BR/137/21/L

Berghestede 1 Shripney Road Bognor Regis PO22 9LW

Listed building consent for replacement of existing non-original sash windows with retention of existing frames.

Drawing Number:
PO22 PR1

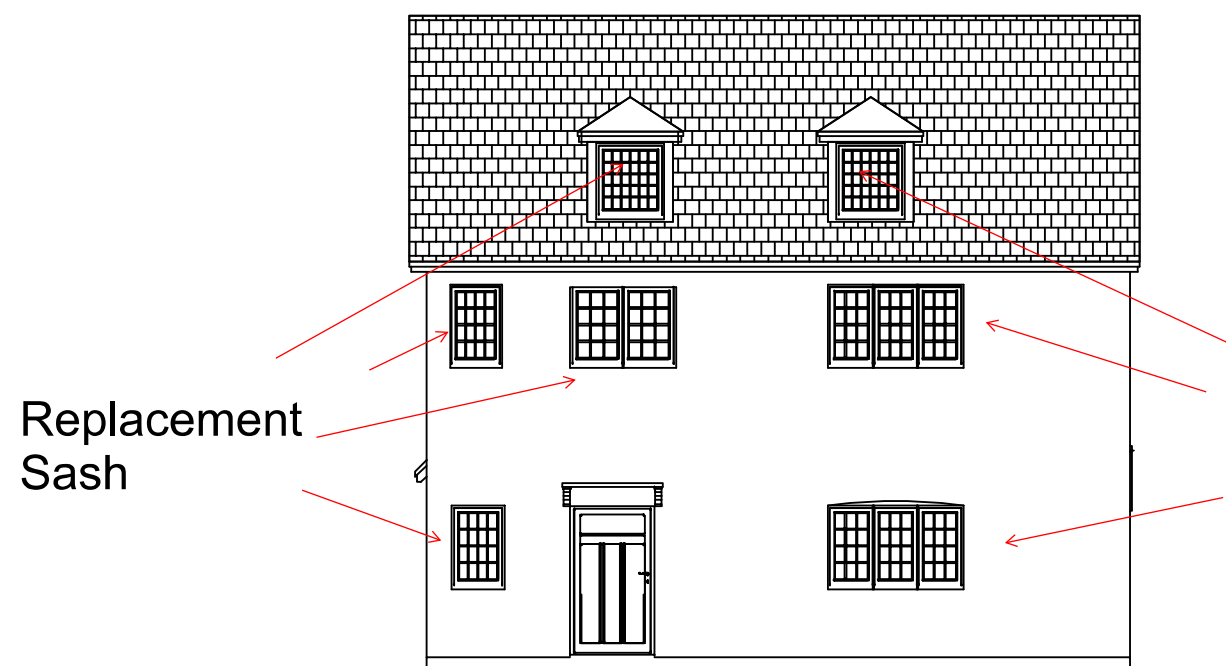
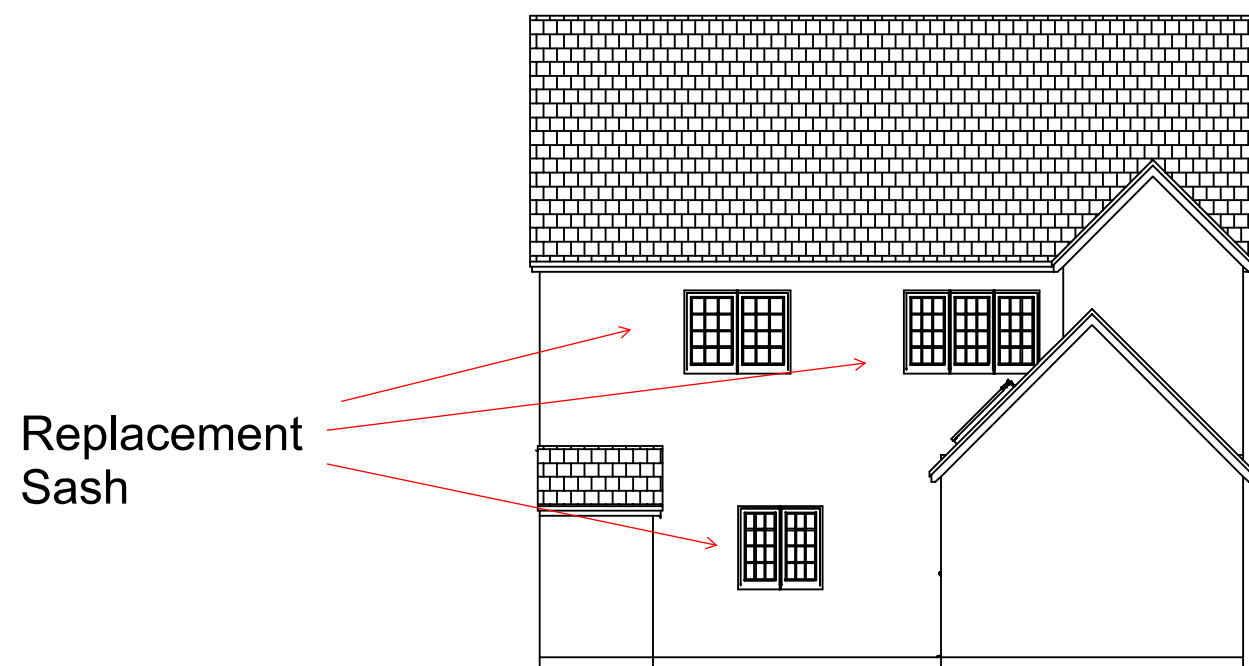
The joinery details appear to only relate to proposed doors as opposed to the windows. They also do not provide any great detail regarding the glazing system to be used, including the relevant dimensions: is it what appears to be 28mm, or the slimmer 12mm system? It is assumed that these would incorporate thermal spacers and applied glazing bars. Whilst a number of sections have been provided, they do not provide full elevational details which makes it difficult to understand what their appearance would be. Would they be the same or different? Unfortunately, it is not clear.

It is also difficult to understand from looking at the information provided how any glazing bars, if any, will be treated which is unfortunate and disappointing. There are two approaches that could be used as part of this proposal: to use glazing bars that are applied to one larger pane of glass or to use properly formed bars, which form part of the structure of the window.

In the first option, false glazing bars are applied to the surface of the window over a larger pane of glass in order to reduce costs and allow a standard double-glazed unit to be used. This approach is historically incorrect, aesthetically unconvincing and not appropriate for a listed building.

The second option requires that the glazing bars are integral to the windows. However, these generally would need to be thicker than the originals in order to take the extra weight of the double glazing (this would also likely be the case even with slimline double-glazed panes due to their size).

Windows such as those proposed (with standard glazing units) tend to lack the subtlety of detailing/profiles of the traditional ones, and will not only increase the perception of modern, standard windows, but also affect the design of the windows themselves. The use of standard double-glazed units will not only increase the perception of modern, standard windows, but also affect the design of the windows themselves. This would harm the character and appearance of the listed building. The same can also be said at times for the much slimmer glazing units.

This type of double glazed unit and window design is therefore not appropriate for a listed building and is considered to cause harm.
